Rezoning Transportation Analysis

Petition Number: 2022-198

From: Jake Carpenter, PE
Jacob.carpenter@charlottenc.gov
980-221-5675

Reviewer: Patrick Monroe
Patrick.Monroe@charlottenc.gov
704-301-1411

RZ-2

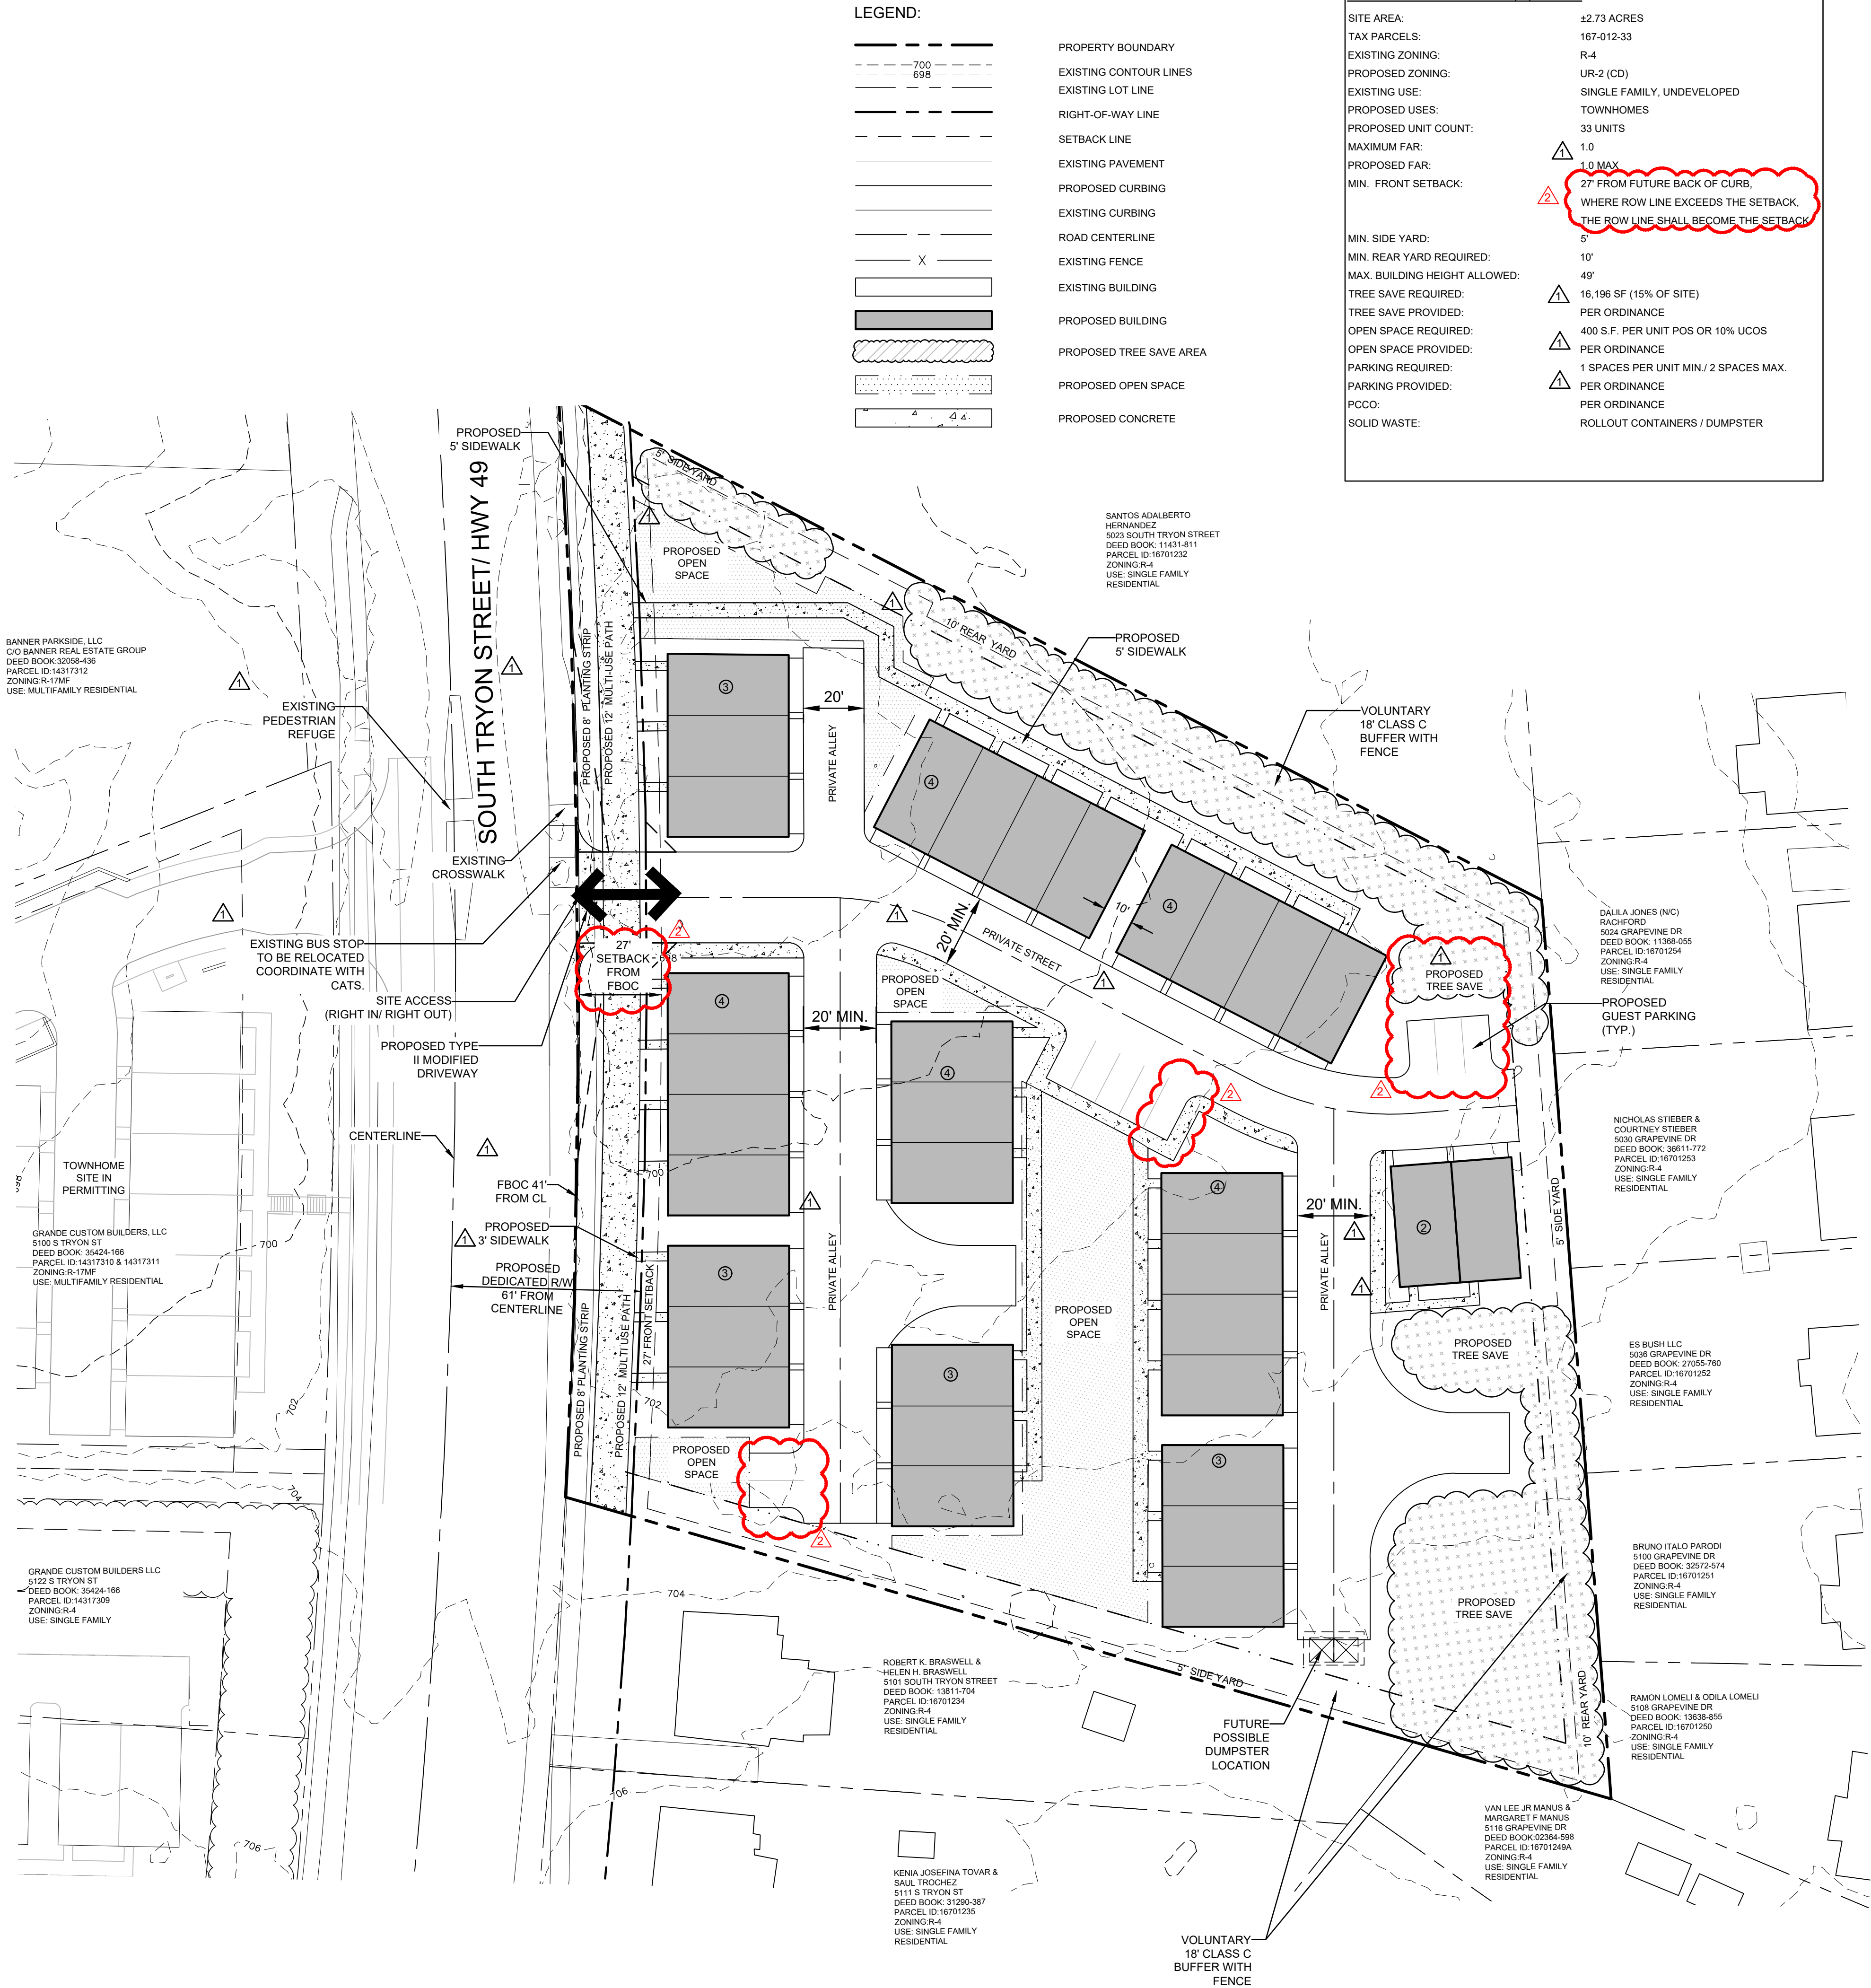
9. Add a conditional note specifying “All transportation improvements will be approved and constructed before the site’s first building certificate of occupancy is issued. The petitioner may phase transportation improvements if said improvements and phasing are explicitly described in site plan notes.”

Outstanding Comment 5.24.2023: Remove the highlighted portion of the comment below.

8. All transportation improvements **required to be constructed by Petitioner under this Section C of the Development Standards** will be approved and constructed prior to the issuance of the first certificate of occupancy for a new building constructed on the Site.
